From: Claire Potts
Sent: 20 June 2017 13:35
To: 'Graham, Laura'
Cc: Michael Eastham
Subject: RE: Comments on Development Framework Document

My comments on the DFD are set out below:

Amended Vertical Alignment Parameter Plan

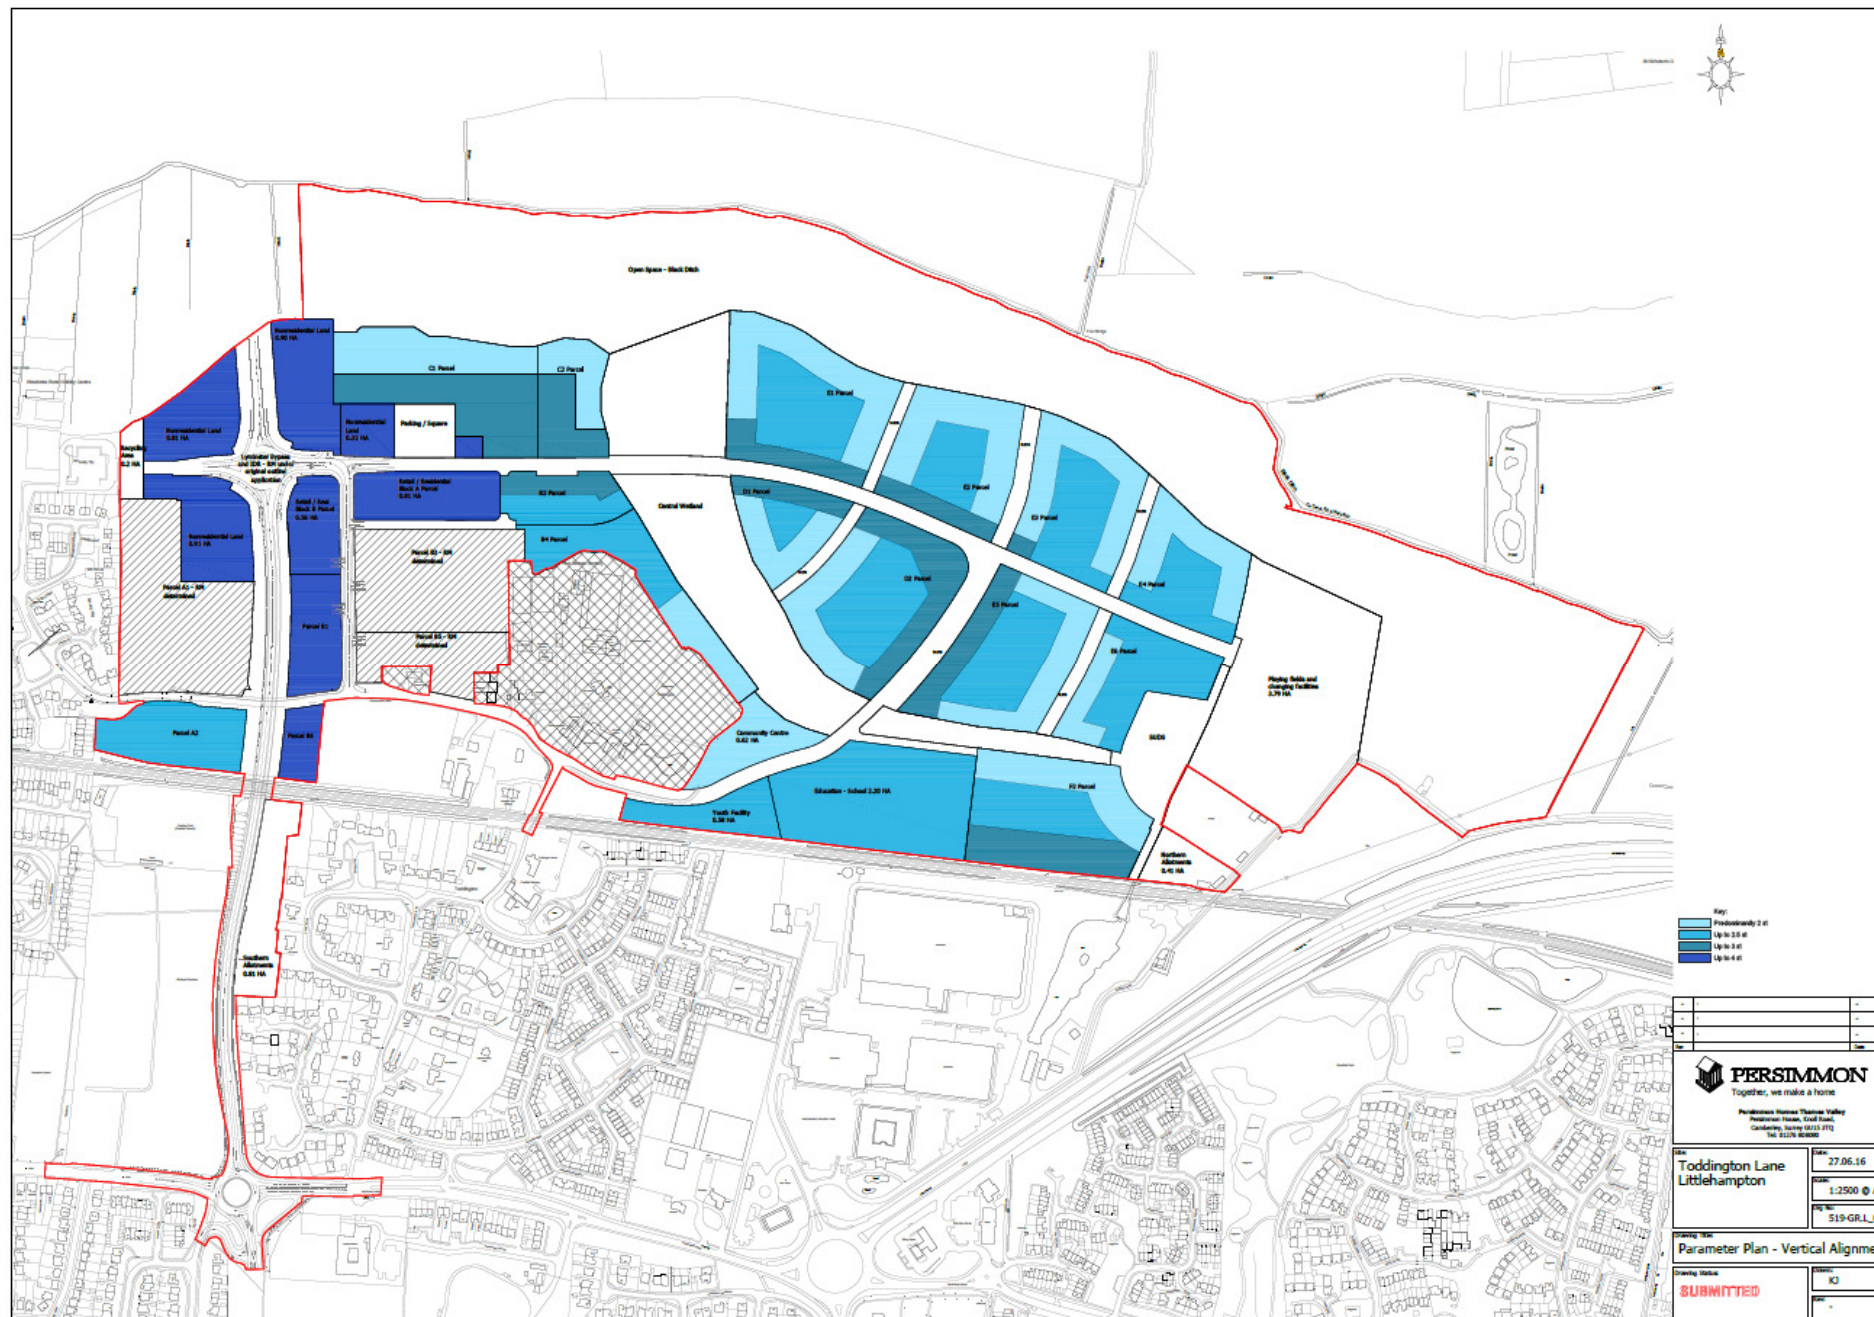
P12 – B6 was originally 2 storey – need to justify how 4 storey will work on this parcel.

Character Areas

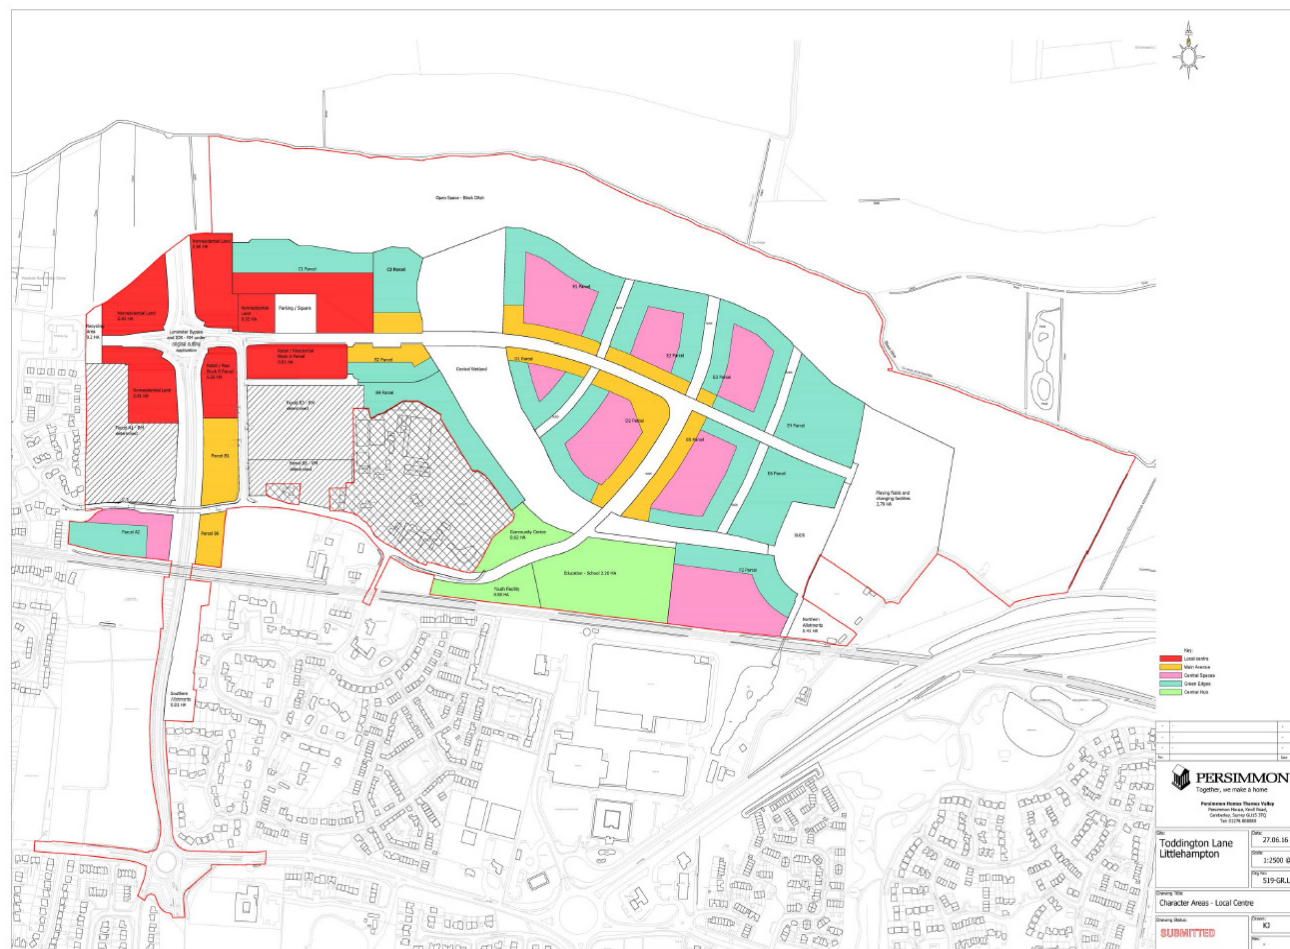
P19 – the rationalisation of the character areas had resulted in the loss of areas which were due to have a different character – which was based on defining principles. For example, the 'natural edge fronting' and 'green space frontage' have been replaced by a single 'green edge' frontage. The Central Open space frontage was different from the green edge as it was based around the more formal nature of the man made park. This provided opportunities for giving a sense of grandeur using detached and semi-detached properties which appear as one detached house. The document also lacks any references to the existing local character and how elements from the local vernacular have been used in the design of new dwellings. What is the role of 'key gates' within the scheme and how will they be defined.
